Recommendation Report for Listed Building Consent for Alterations, Extension or Demolition of a
Listed Building

REF NO: R/98/26/L

LOCATION: The Lodge
Worthing Road
Rustington
BN16 3PS

PROPOSAL: Listed building consent for replacement of 6 No. existing windows within the main dwelling with timber framed, double glazed, leaded light effect windows and replacement of 2 No. windows and 1 No. door in 1980's rear extension with slimline, leaded light effect, heritage aluminium windows and door.

EXISTING ELEVATIONS

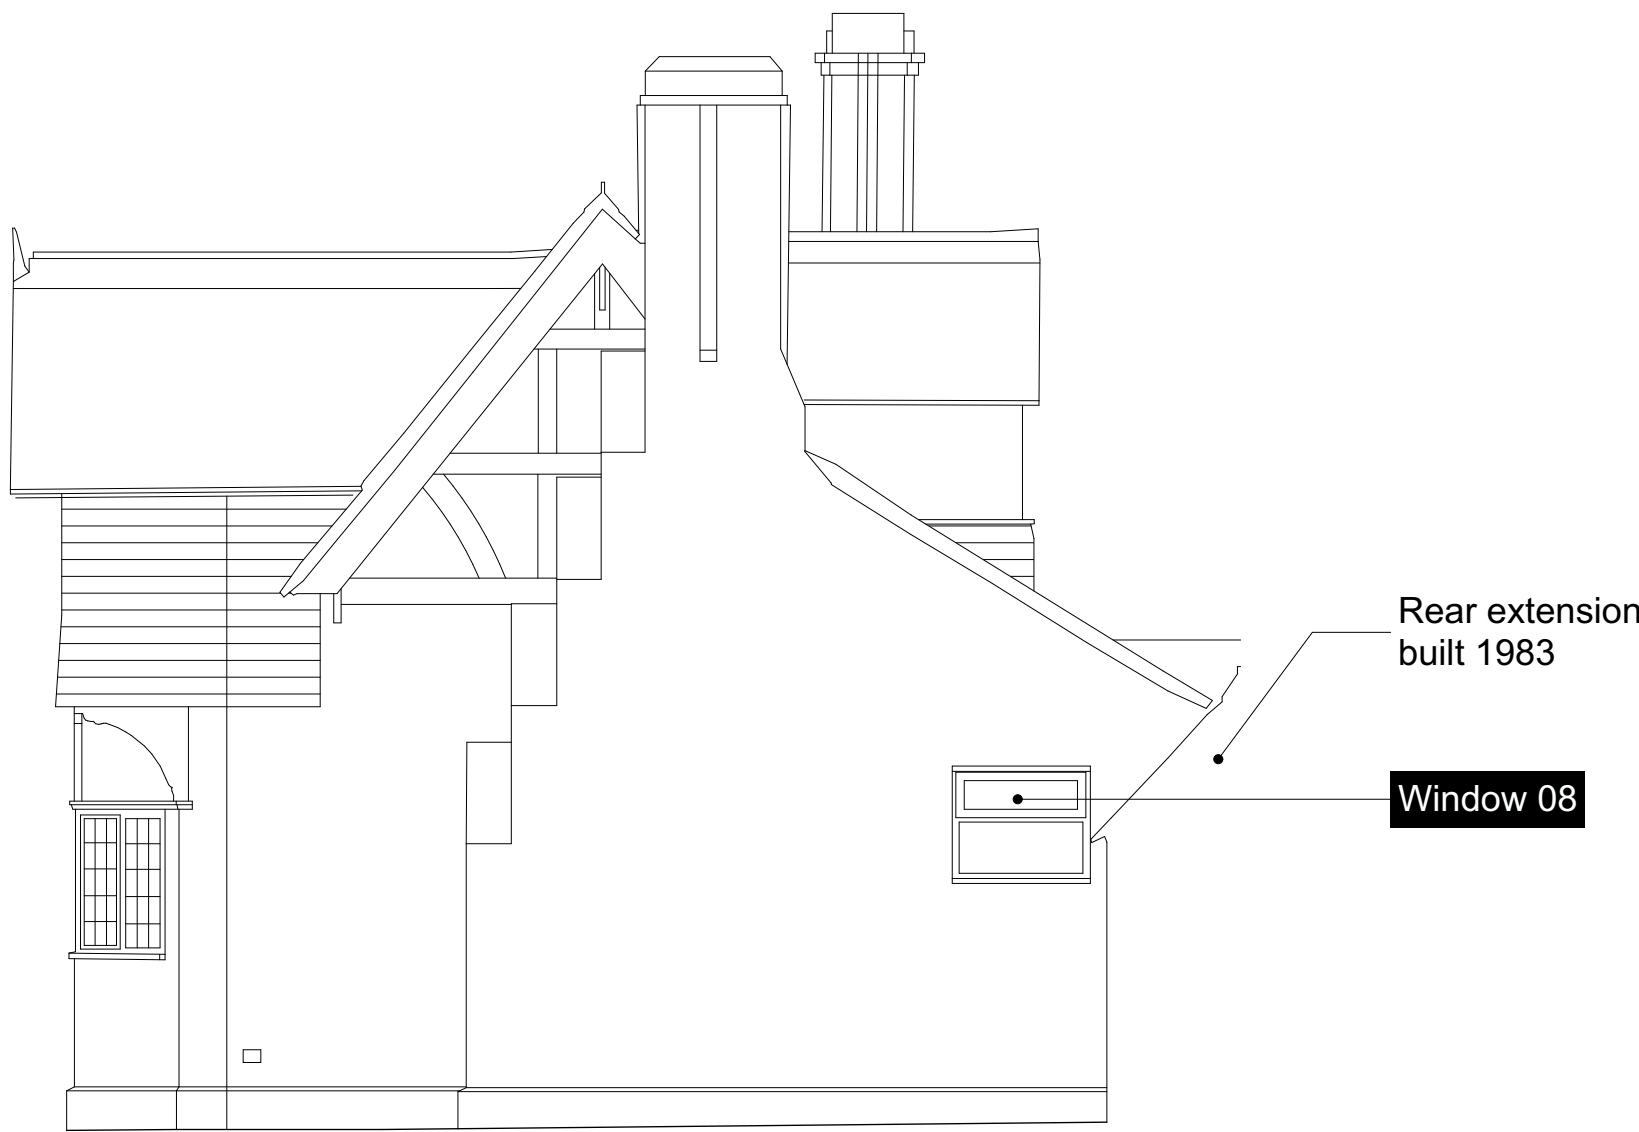
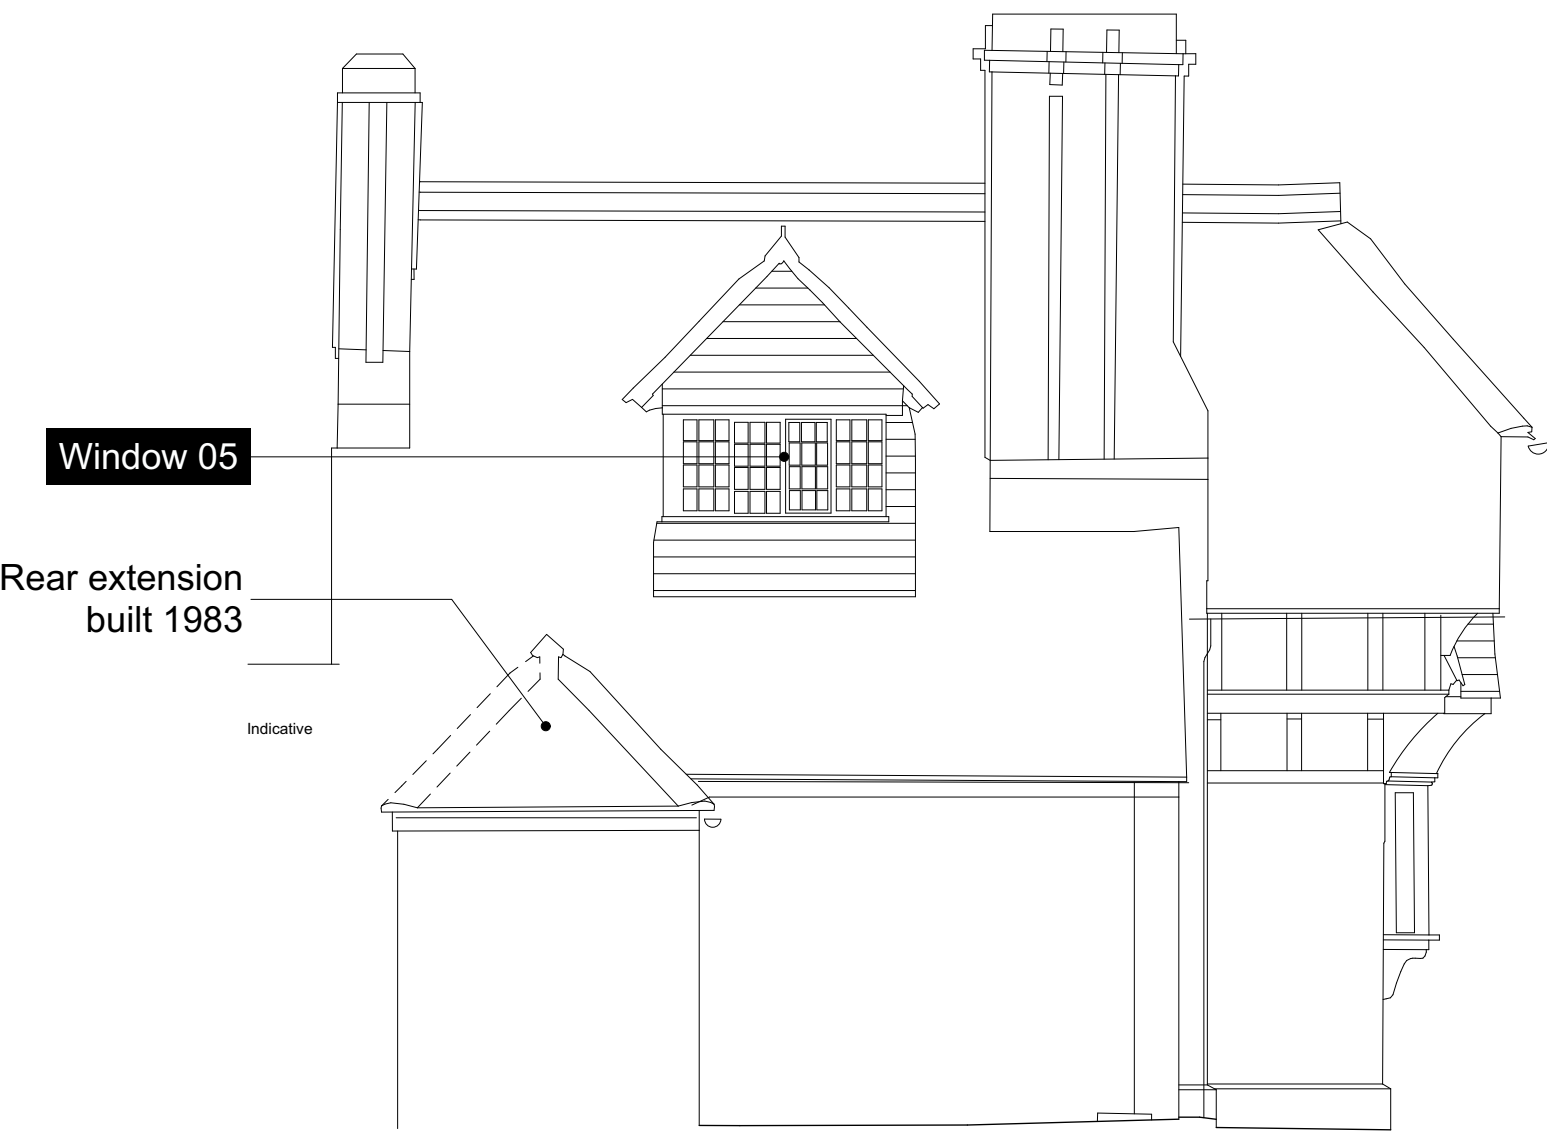
The existing windows within the original part of the building are traditional leaded-light windows with slender metal casements set within timber frames. As such, they make a positive contribution to the character and significance of the listed building.

Historic England advises that traditional windows are often an important part of a listed building's significance and that their alteration or replacement can have a profound effect on its character and appearance. From a previous site visit, and references within the submitted drawings, it is clear that the windows are in a poor state of repair. However, no condition survey or other supporting information has been submitted to demonstrate that the windows are beyond repair or that replacement is the only viable option.

PROPOSED ELEVATIONS

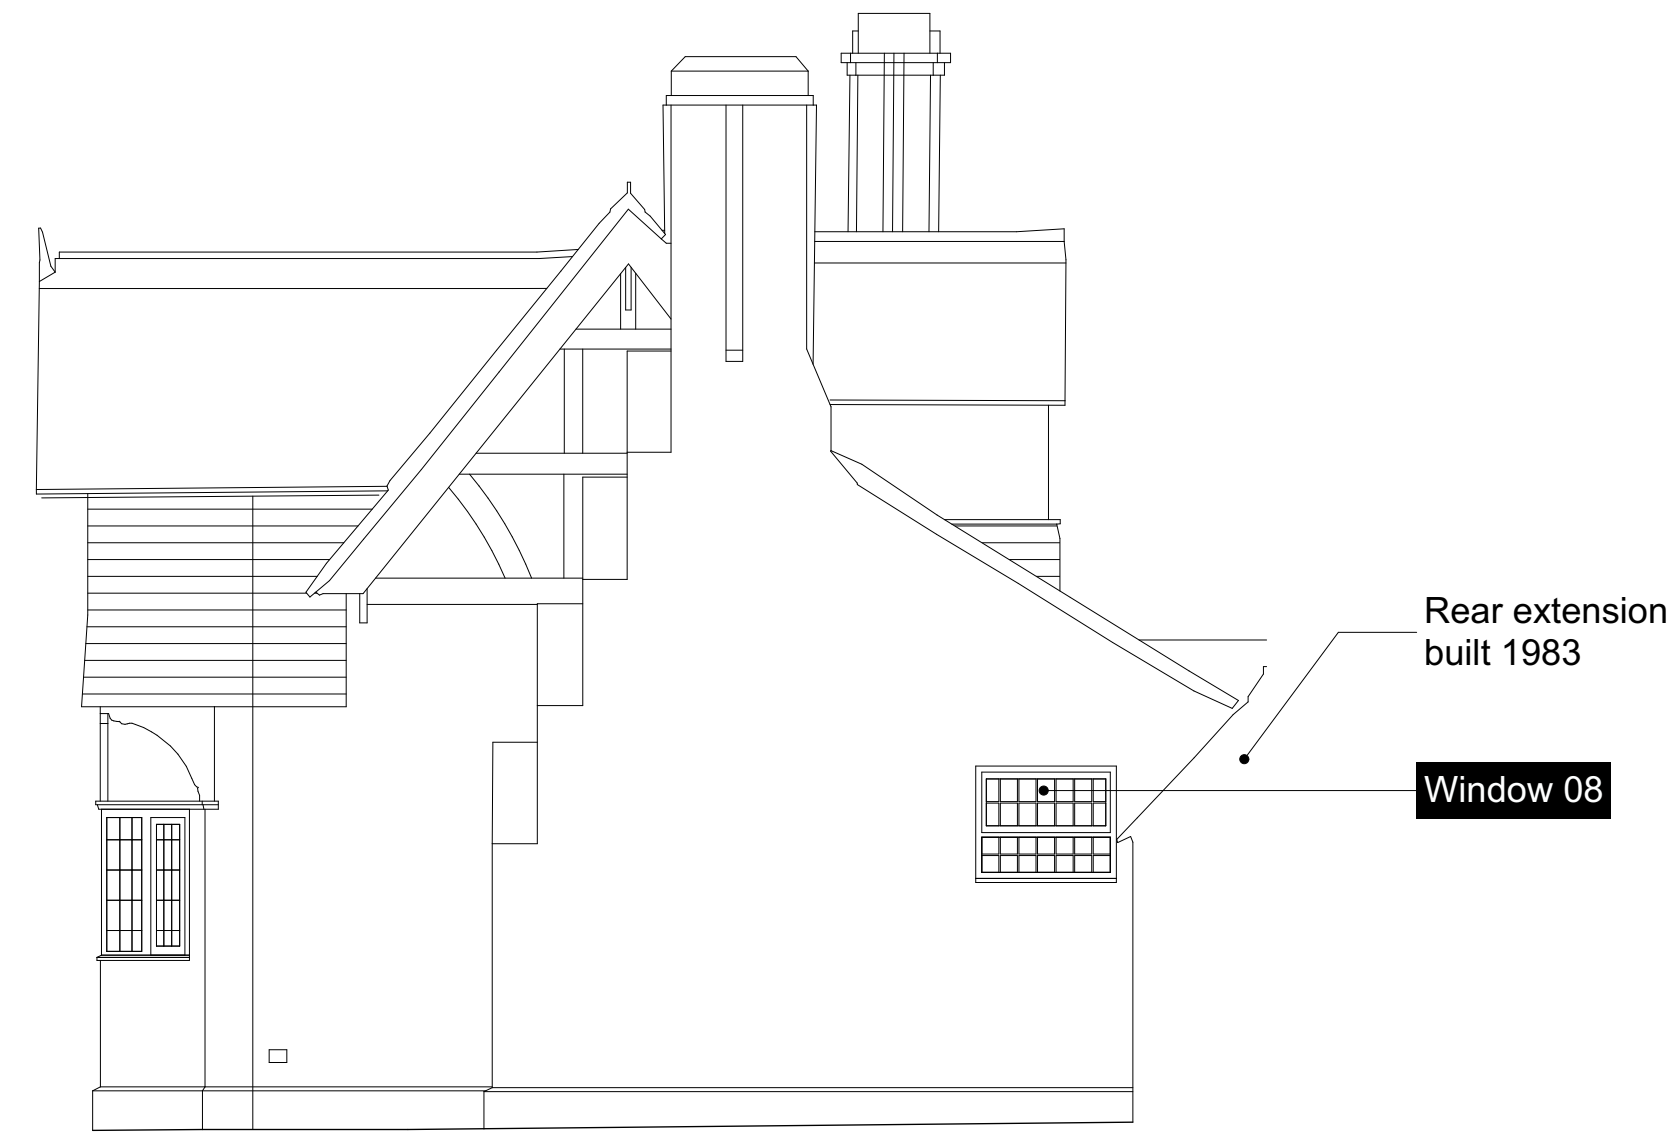
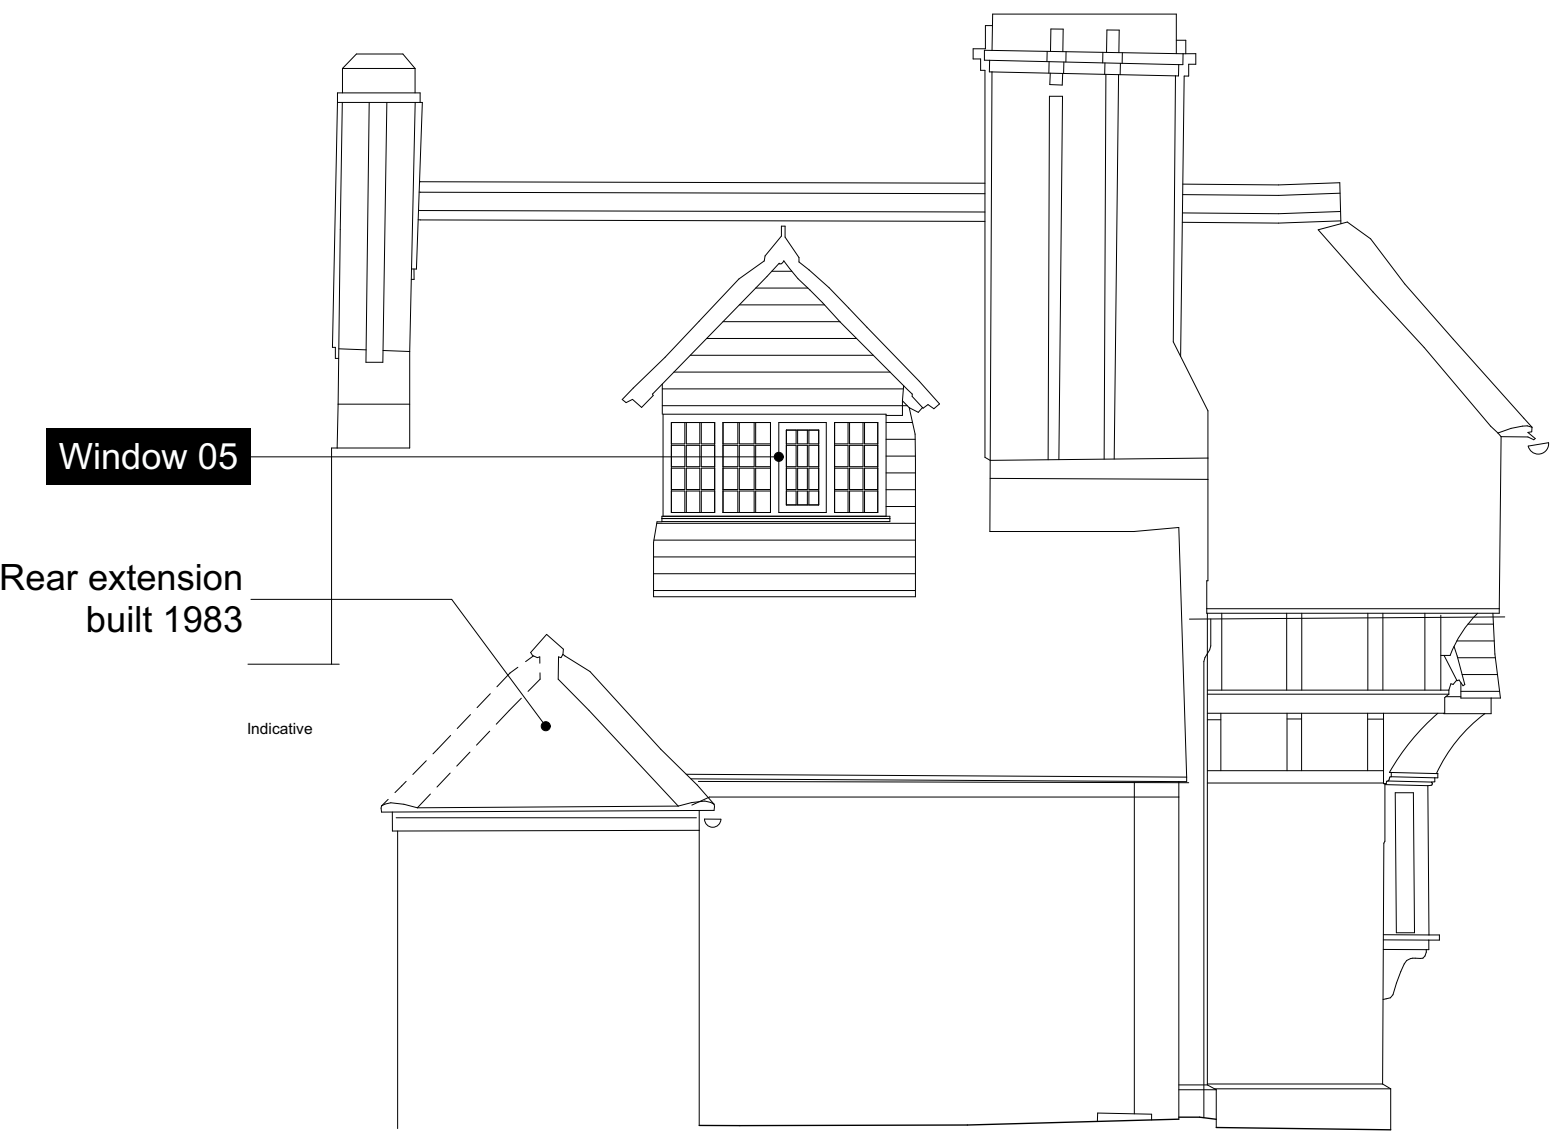
Furthermore, whilst replacement may be acceptable where repair is not possible, the proposed windows would fail to preserve the appearance and character of the existing windows. The incorporation of slim double-glazed units and applied leadwork necessitates altered frame profiles, resulting in a noticeably heavier and less refined appearance than the traditional single-glazed leaded lights. Applied leadwork does not replicate the depth, texture or craftsmanship of true leaded lights and would erode the historic character of the windows. As such, the proposal would result in harm to the significance of the listed building. Consideration should therefore be given to repair, or replacement on a like-for-like basis, potentially combined with sensitively installed secondary glazing.

The proposed aluminium windows within the later extension are acceptable in principle as they would not affect historic fabric. However, it is unclear why the proposed designs have been chosen. For example, Window 07 could be redesigned to better reflect the character of the building, whilst the proposed door would benefit from a simpler design with less, or no, applied lead detailing.
